RE: SUB19-002/SEP19-005 – Proposed Preliminary Plat
2825 W. Mercer Way, APN 2174502425
Request for Additional Information, Third Review
Blueline Job No. 13-118

This letter is in response to your review of the SUB19-002/SEP19-005 project. The plans have been revised per the comments in your letter dated 1/09/23. Below is a list of each comment with our responses in bold.

2/16/23
JOB NUMBER: 13-118
SHEET NAME: RS-01
SHT 6 OF 9

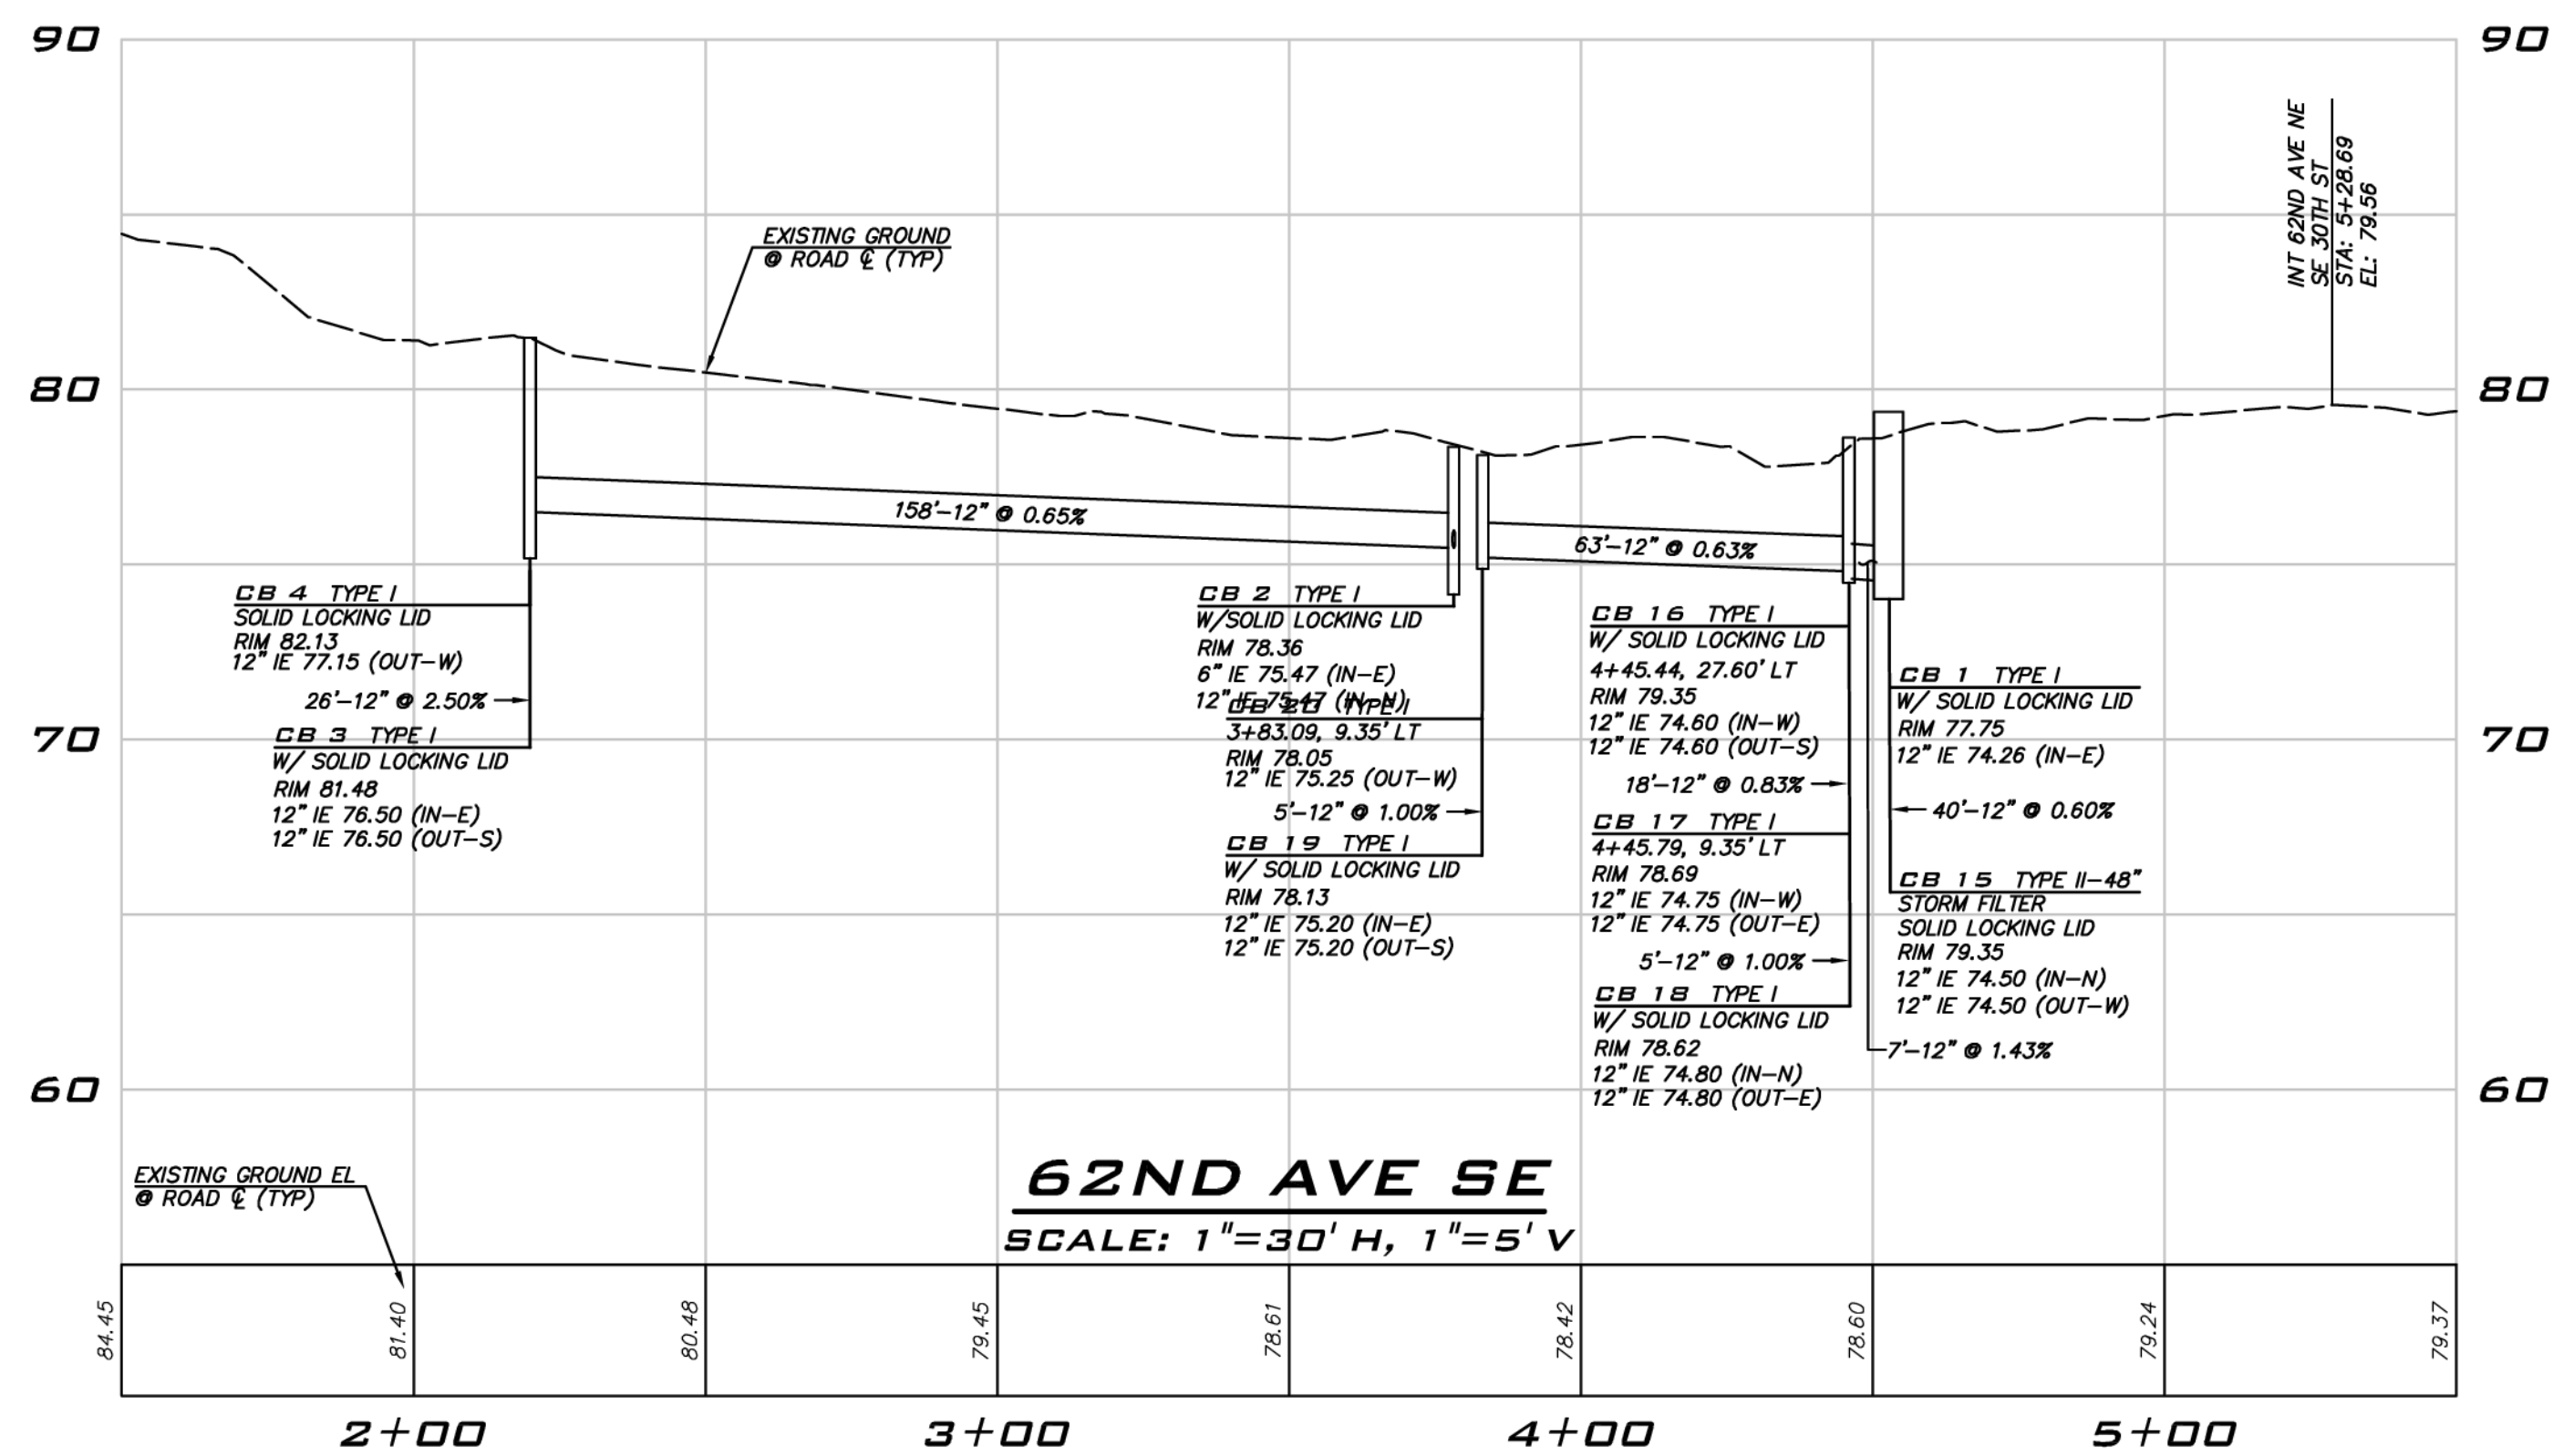
7. Fire Turn Around- Meets Standards
IFC 503.2.4 The required turning radius of a fire apparatus access road shall be determined by the fire code official. (See Appendix B)
Applicant must identify turn around area on plat map and provide a plan on how this area will be maintained for fire access only and not parked vehicles. Examples would be painted lines (maintenance agreement) and/or signage.

Noted. A callout for the fire turnaround has been added to sheets SP-01 and RS-01.
